APPLICATION NO: A/46/18/RES

Site Address: Land west of Brook Lane and South of A259 Angmering

Description of Works: Approval of reserved matters following outline consent A/169/17/OUT for access. This application is a Departure from the Development Plan and also lies within the parishes of Littlehampton & Rustington.

scale	1:500@A3	drawn by	OAN	checked by	VL
date	JUNE 2018	cad file	Master 2018-06-06.DWG		
drawing number	SPRUST(BROOK LANE).1/10				rev.
					A

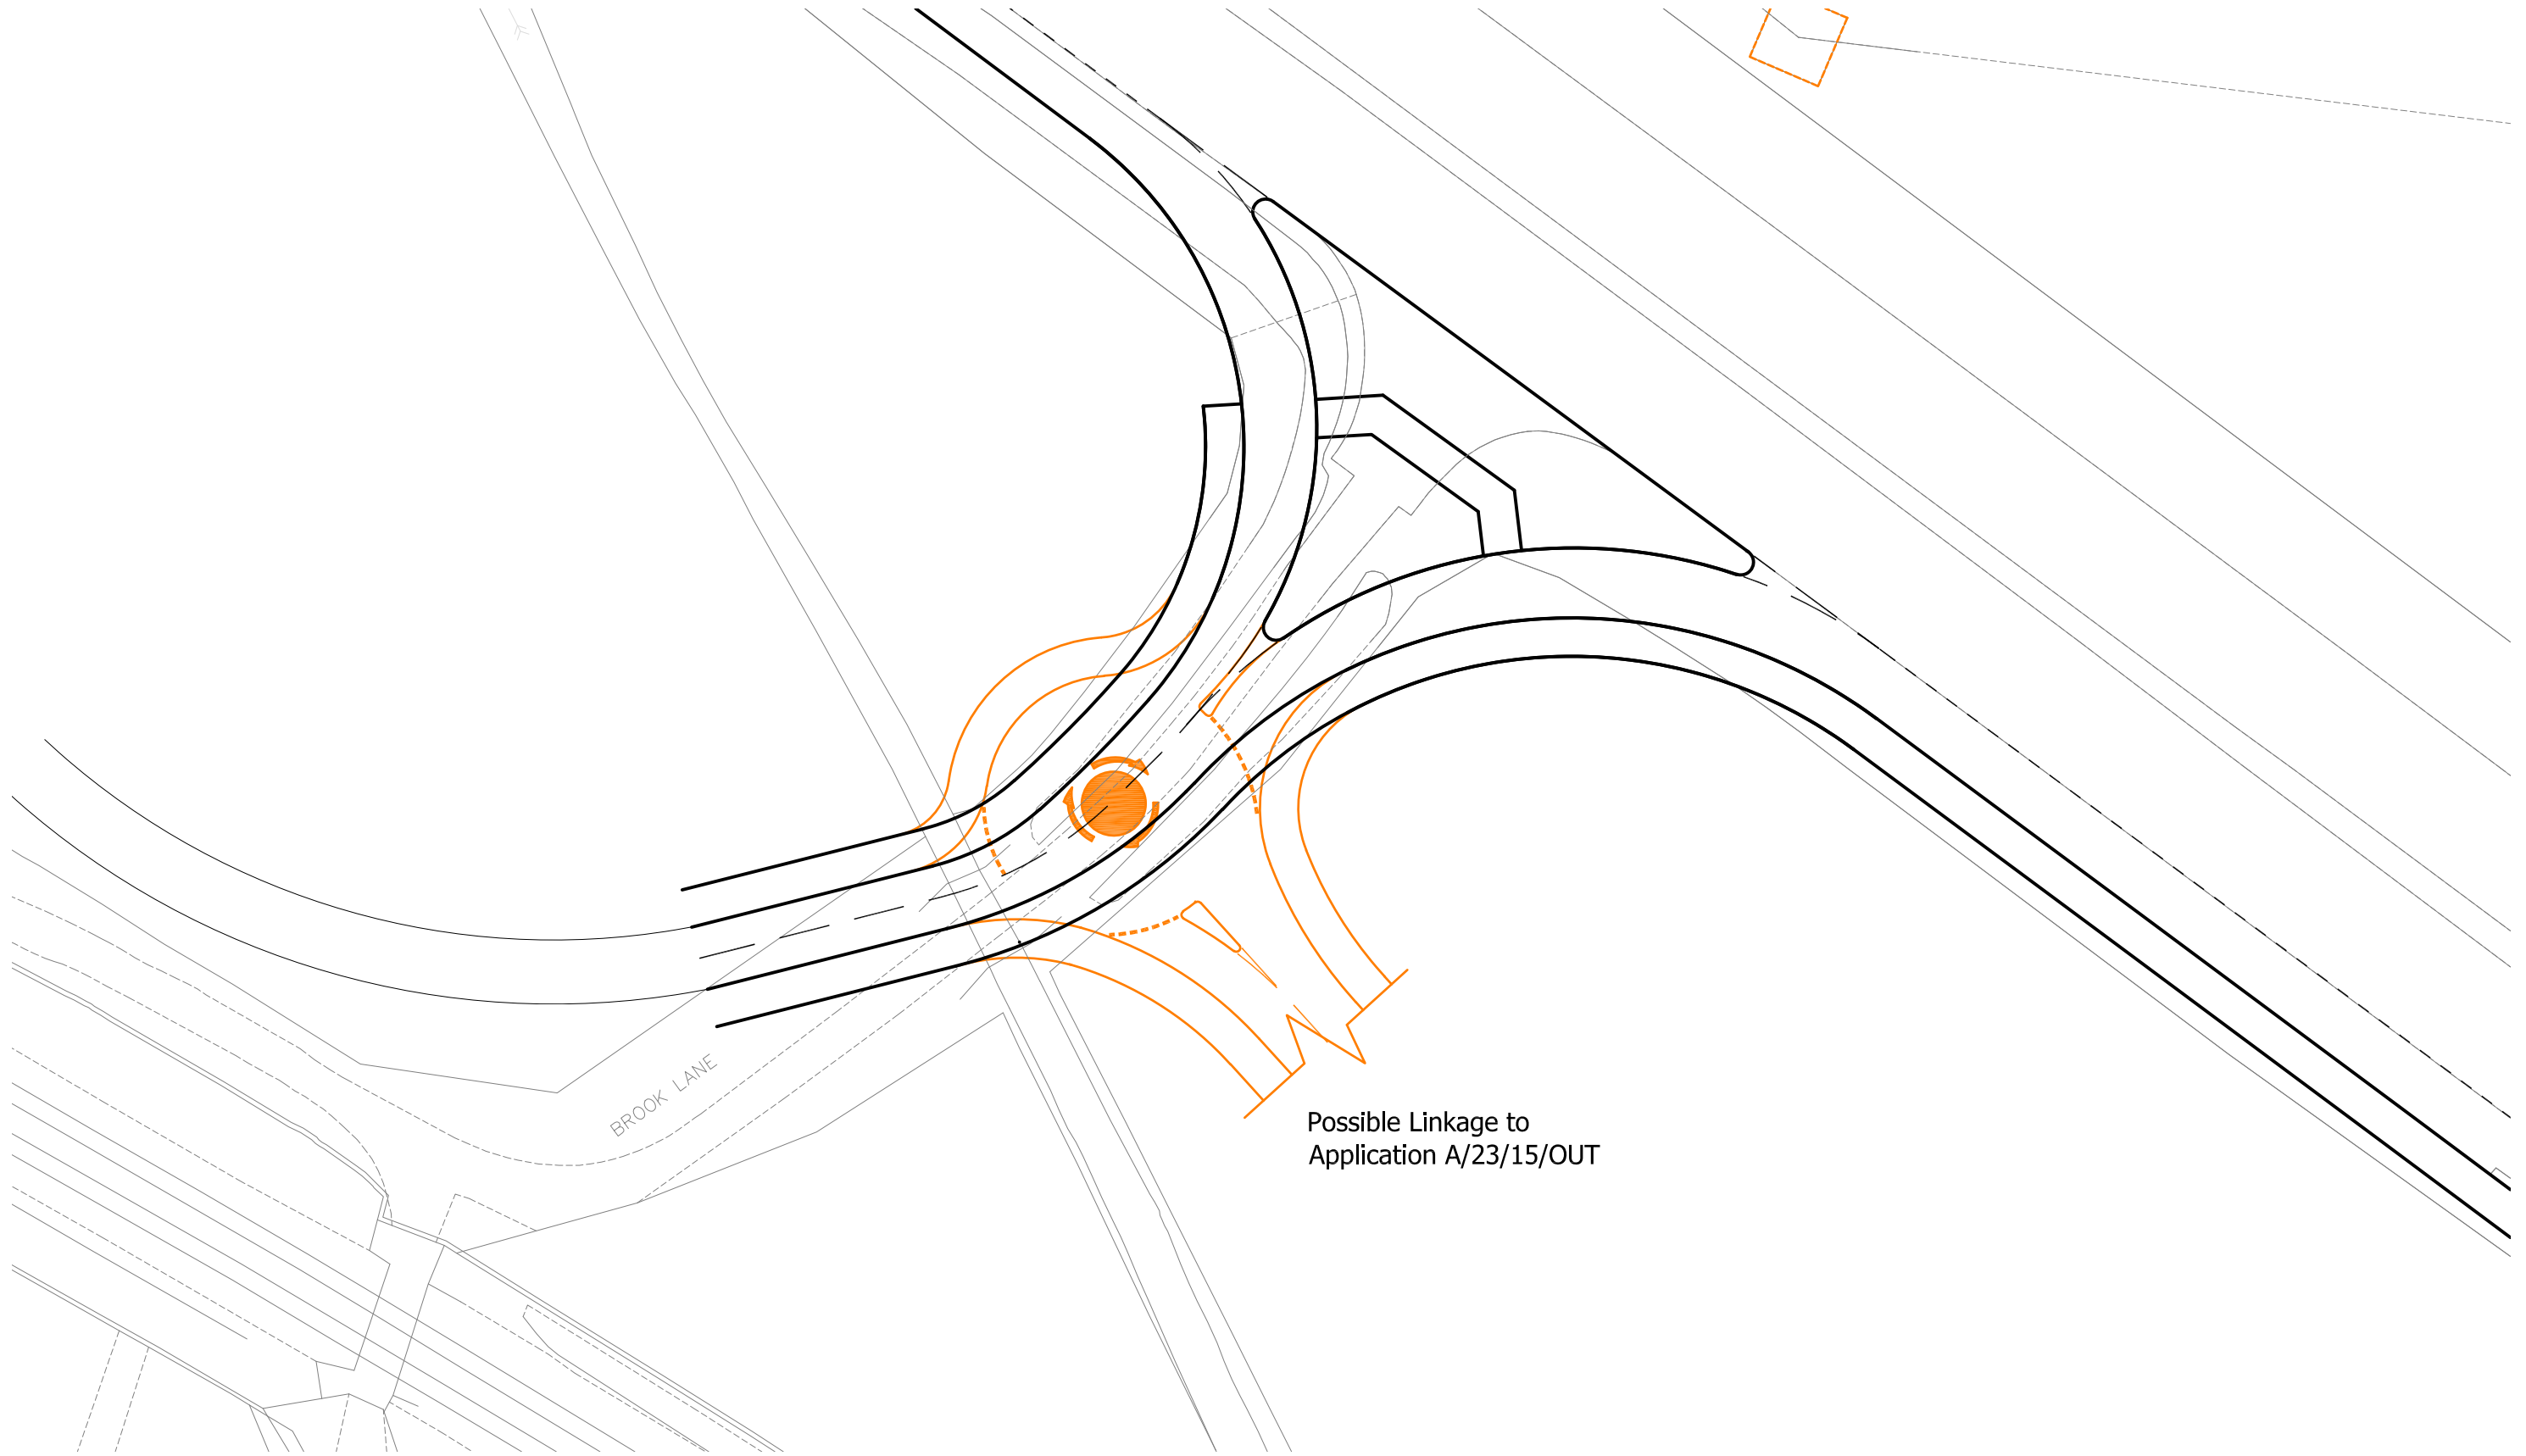
An objection is raised to the proposed access. As per the ongoing correspondence with regard to planning application ref A/11/17/OUT for the adjoining site the applicant needs to demonstrate that a safe and sustainable access can be provided to both their site and does not preclude access to the adjoining site. At the moment they have not done this and the proposed access arrangements from both sites are conflicting. A revised drawing needs to be submitted that demonstrates how access can be provided to their site and the adjacent.
